OXFORDSHIRE COUNTY COUNCIL'S RESPONSE TO CONSULTATION ON THE FOLLOWING DEVELOPMENT PROPOSAL

Application no: 16/02586/OUT

Proposal: Phase 1 of the proposed new business park ("Bicester Gateway") comprising up to 14,972 sq m (Gross External Area) of B1 employment based buildings, plus a hotel (up to 149 bedrooms), with associated infrastructure, car parking and marketing boards.

Transport

Drawing Number: **35172/5502/006**

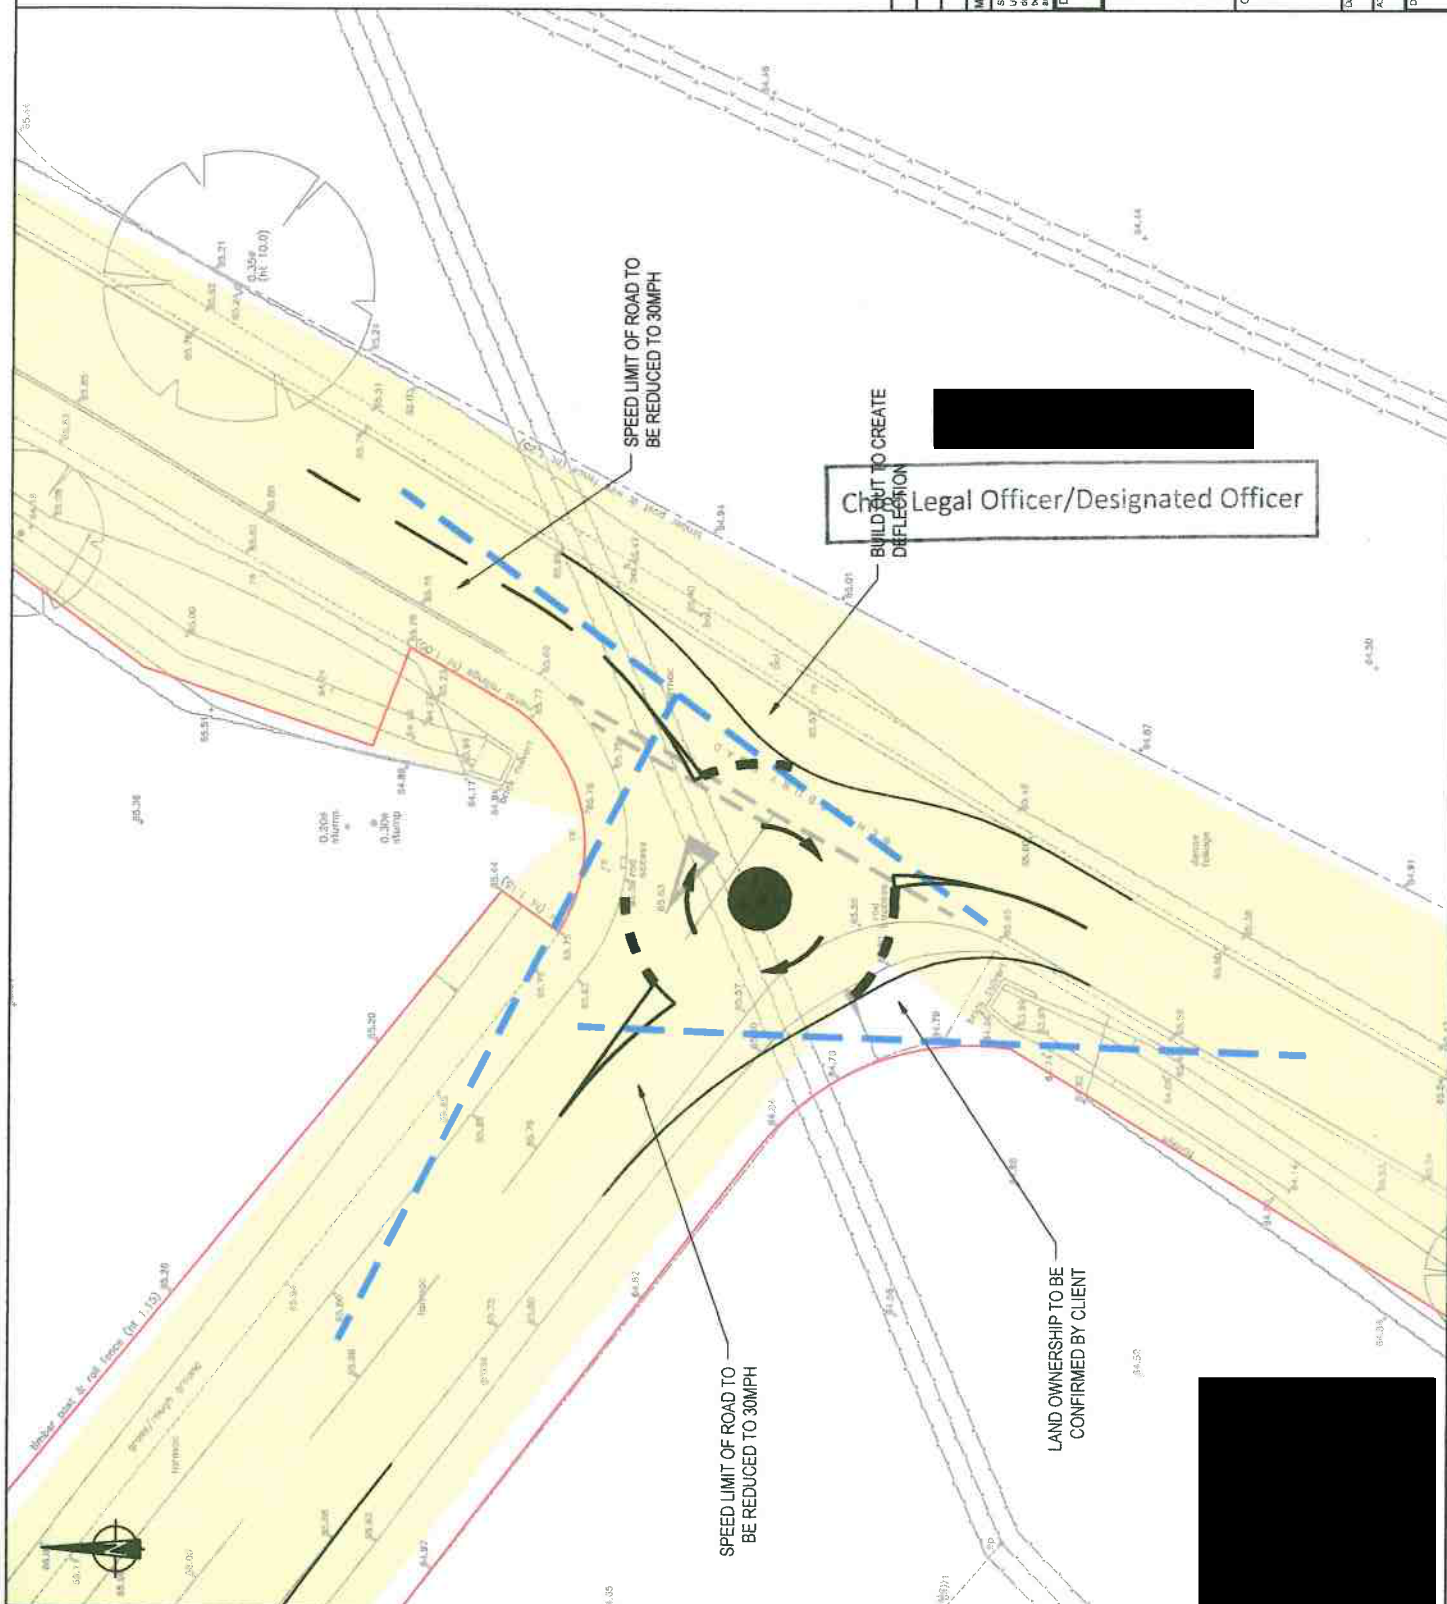
- Shared use cycle/footway on A41 north of Vendee Drive roundabout along hotel frontage - signed S278 agreement prior to commencement, delivery prior to occupation of the hotel

- Shared use cycle/footway on A41 south of Vendee Drive roundabout along Phase 1b frontage and linking into the development - signed S278 agreement prior to commencement of Phase 1b, and delivery prior to occupation of Phase 1b

I am prepared to accept that additional footway to the south of the Vendee Drive Link Road is not required for the office development, as it would not be a significant detour for pedestrians to access Bicester Avenue via the proposed new footway/cycleway along the A41 frontage.

Date of 1st issue	24.11.2016	Designed	JHo	Drawn	JHo
A3 Scale	1:250	Checked	PC	Approved	FC
Drawing Number	35172/5502/007	Revision	-

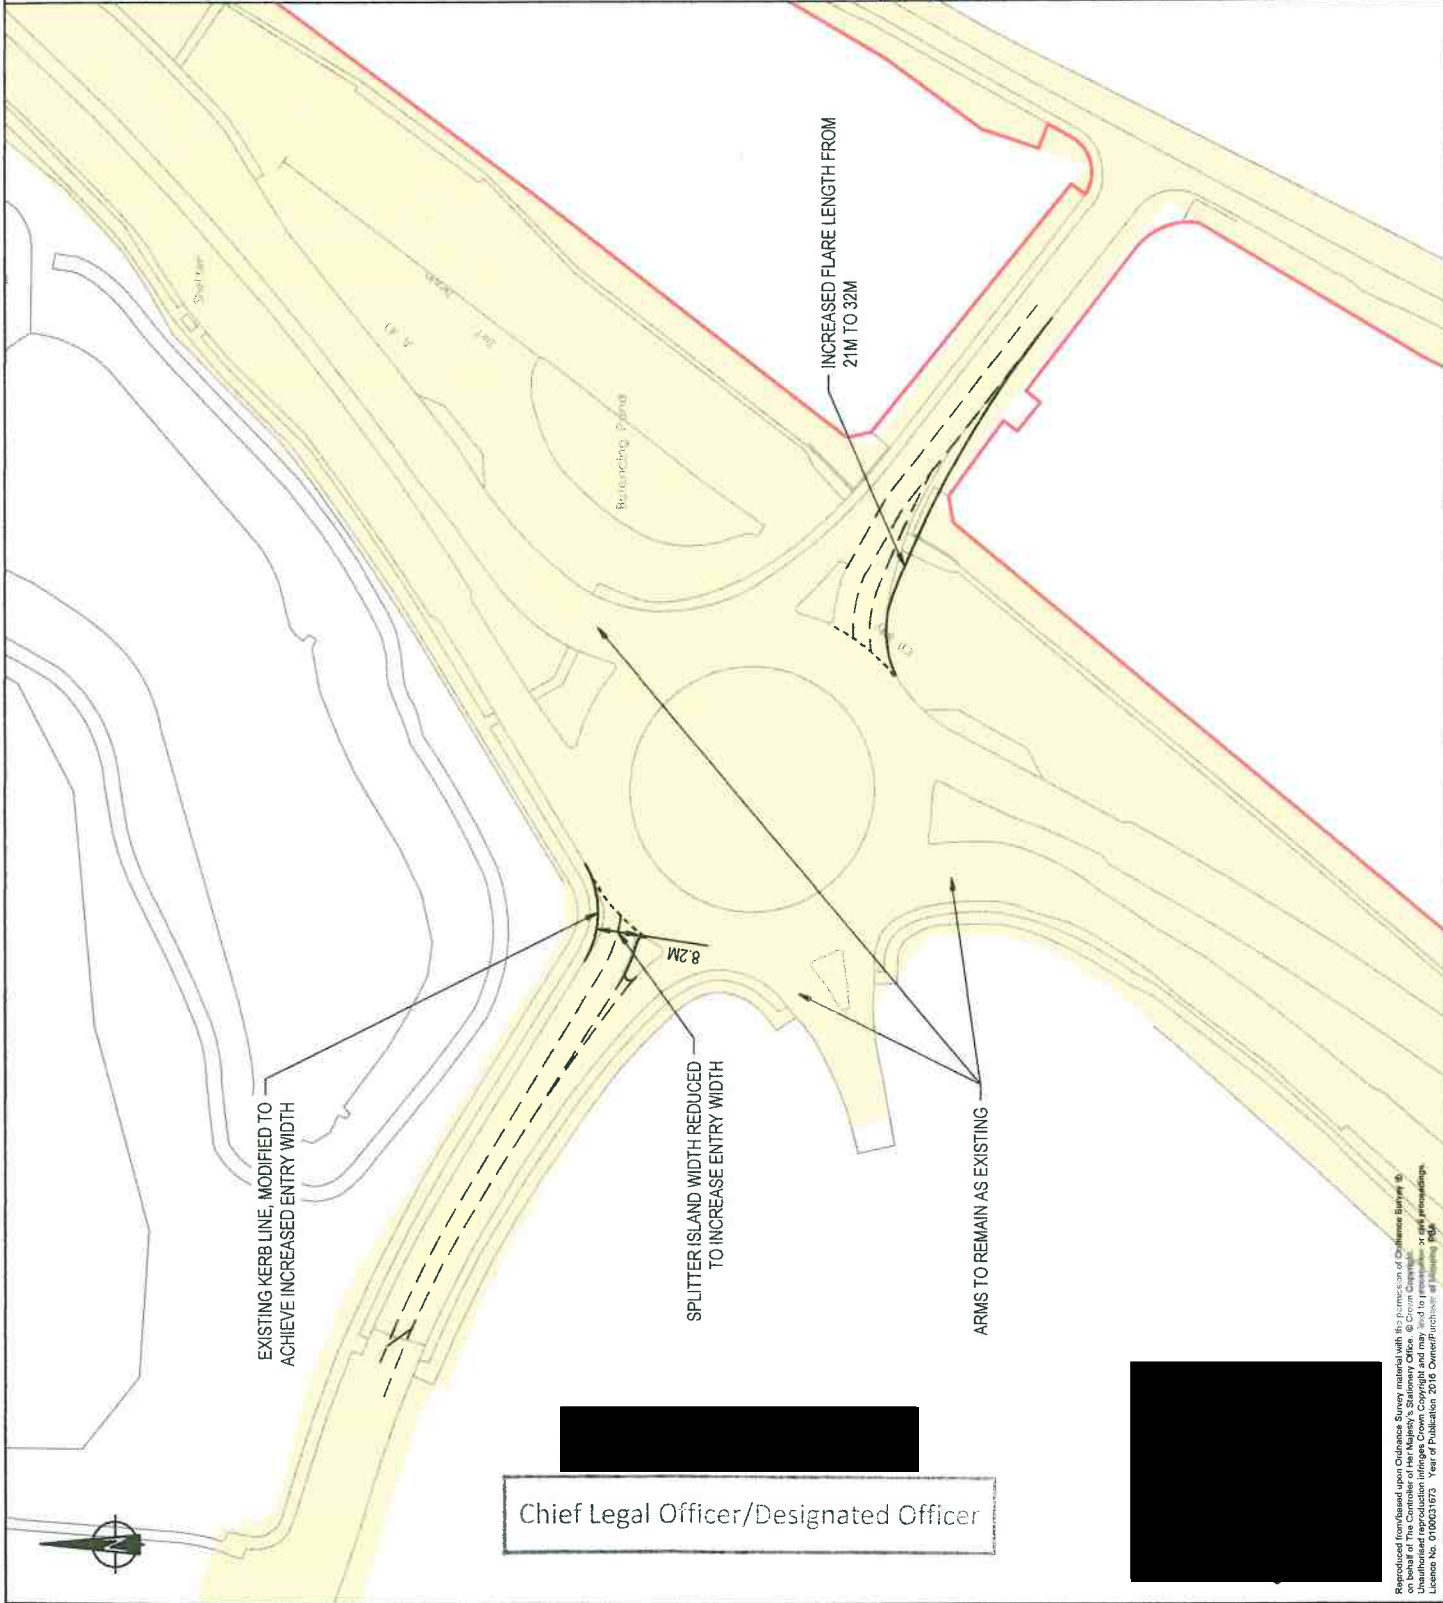
The applicant has demonstrated that sufficient visibility can be provided at the hotel access, both for the proposed speed limit reduction and in the event that the required TRO is not made. The detail of this access should be required by condition and a S278 agreement should be required prior to commencement.
